SUBJECT: WDFW COMMENTS ON MOULTON SHORT PLAT (SP-26-00004)

Thank you for the opportunity to comment on the two lot Short Plat proposed at 711 Bitterbrush Drive, parcel number 951011. The Washington Department of Fish and Wildlife (WDFW) has reviewed the application materials available on file and we have specialized knowledge of the wildlife and critical areas surrounding the project area. As an agency of expertise, we offer the following comments to be considered as part of this review and determination process.

## Critical Areas

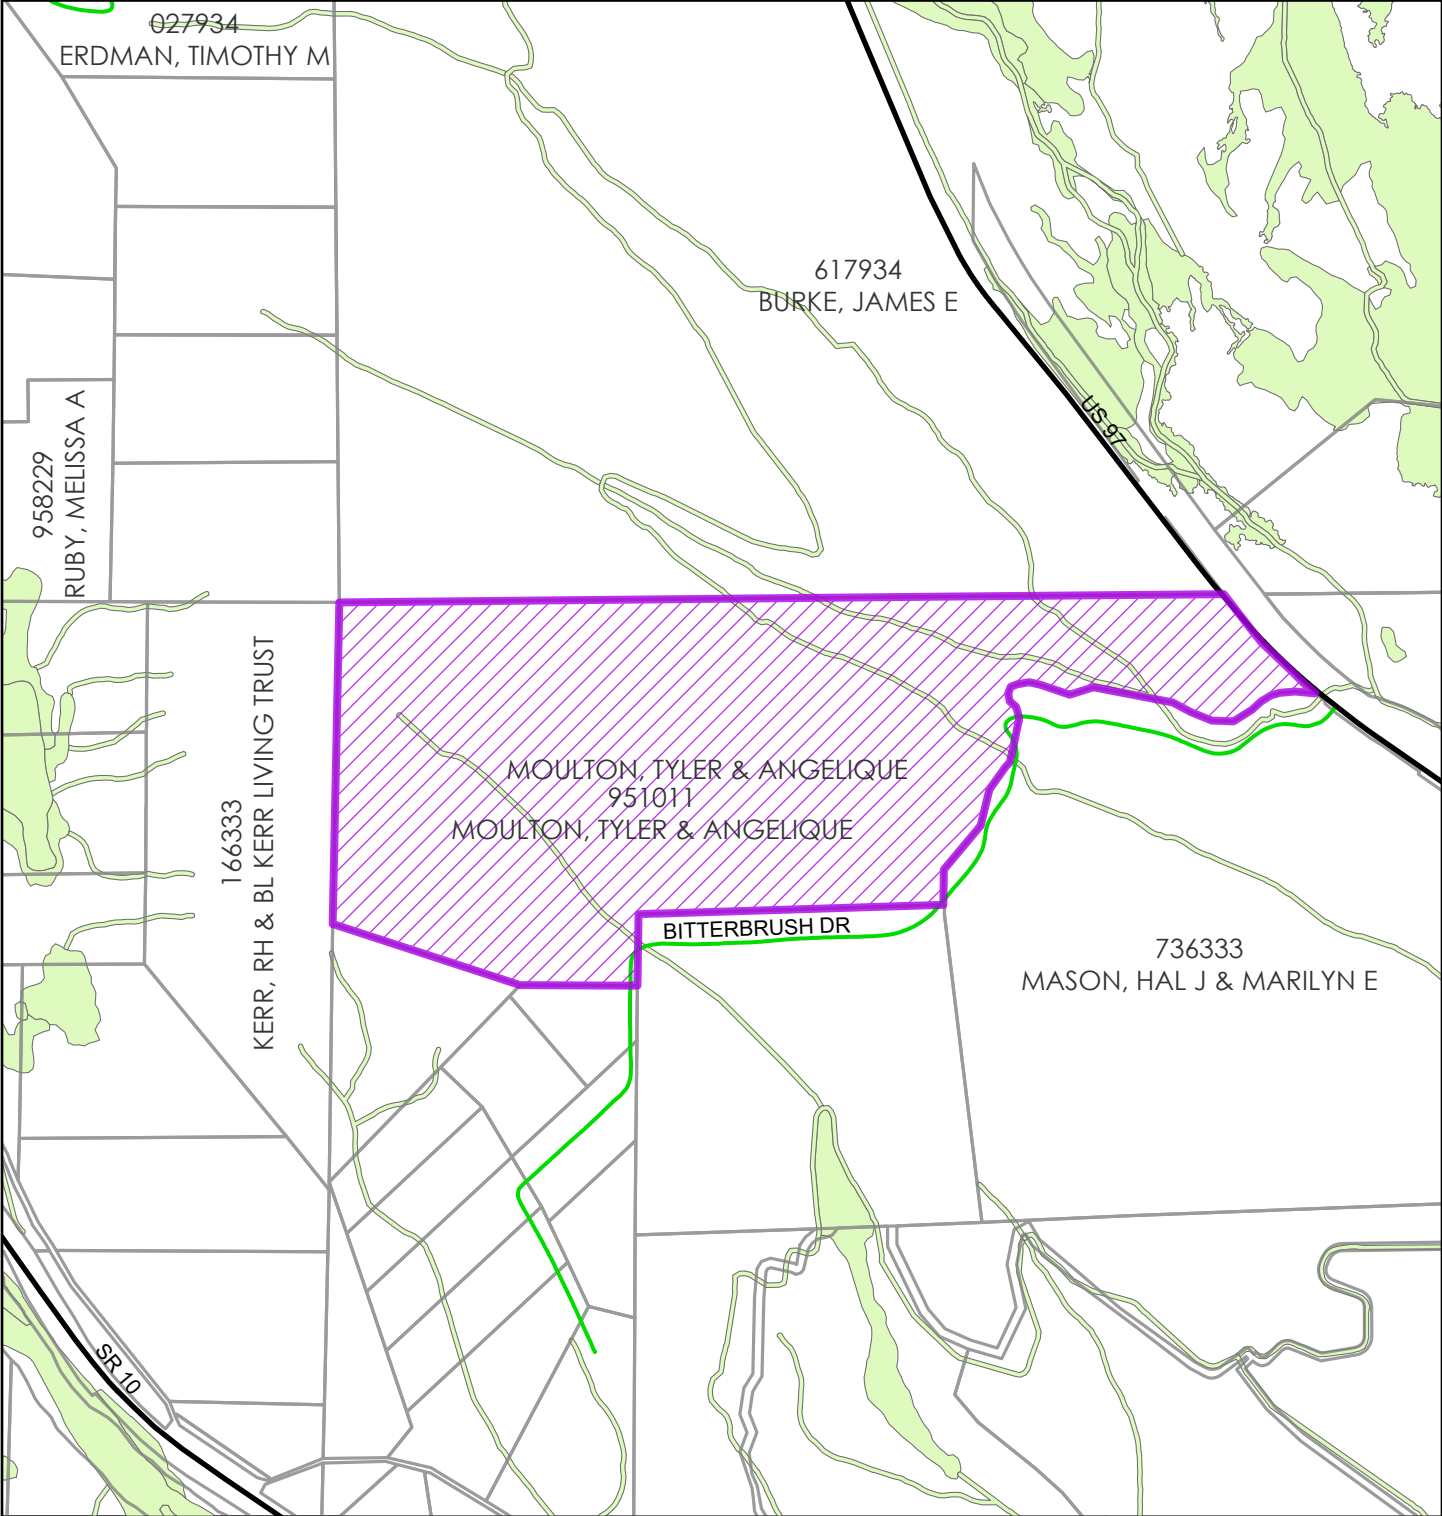
The parcel proposed for this short plat contains shrubsteppe habitat and Mule Deer winter range habitat; both are identified in WDFW's Priority Habitats and Species (PHS) program and are designated Fish and Wildlife Habitat Conservation Areas under Kittitas County's Critical Areas Ordinance (KCC 17A.04).

WDFW recommends that these critical areas be included in the Critical Areas Map provided with the application materials and/or as part of the final plat approval. Providing clarity now on the critical areas present will help ensure all future development proposals are aware of these critical areas and the appropriate mitigation measures will be applied to address any potential impacts to shrubsteppe habitat. Future development on these lots should follow mitigation sequencing to minimize disturbance and mitigate for the unavoidable impacts.
